Your ref: 3.20.0377
Our ref: D1.20.0377
Date: 15th June 2020

App no: **20.0377**

Address: **Land at Eastham House Farm Mitton**

Proposal: **Proposed change of use from existing agricultural unit (Class B8) to Industrial Unit (Class B2)**

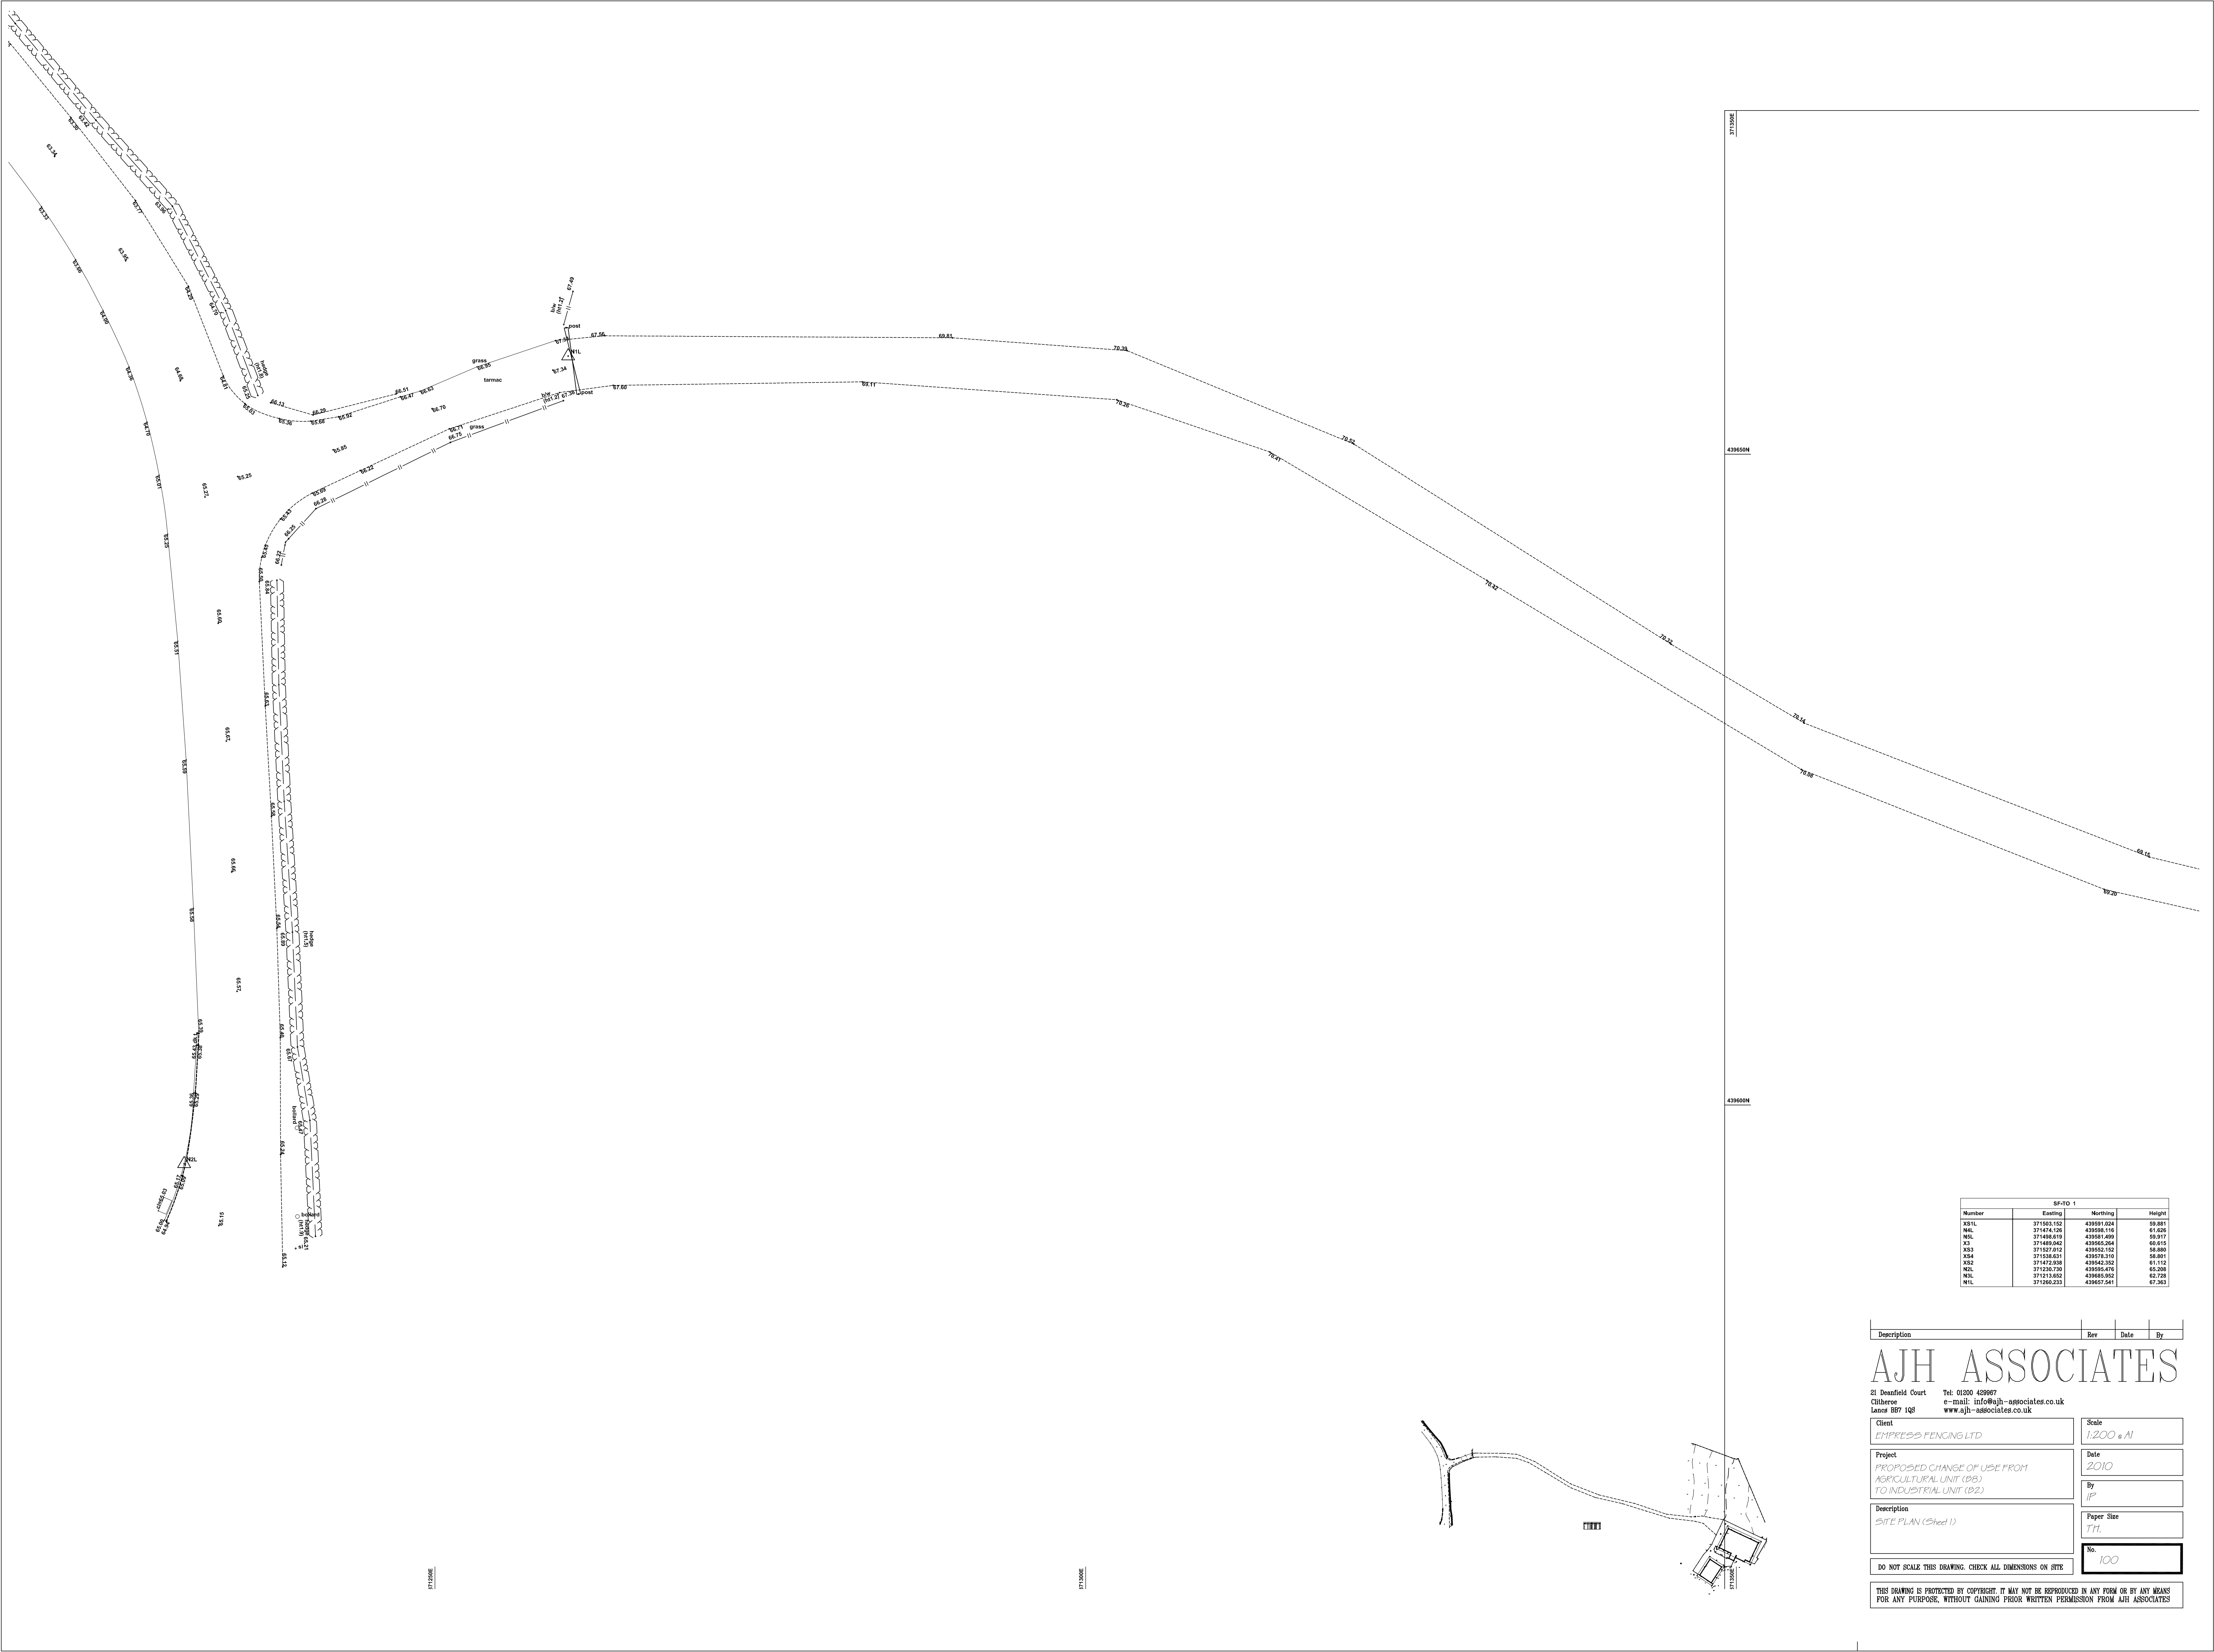
The existing site access provides suitable visibility splays in both directions on Clitheroe Road U3220 and is suitably wide enough for large vehicles to manoeuvre.

There are no public rights of way recorded in the vicinity of the building. There is a public footpath recorded along the unnamed site access road for approx. 30m before it enters the field in a north easterly direction.
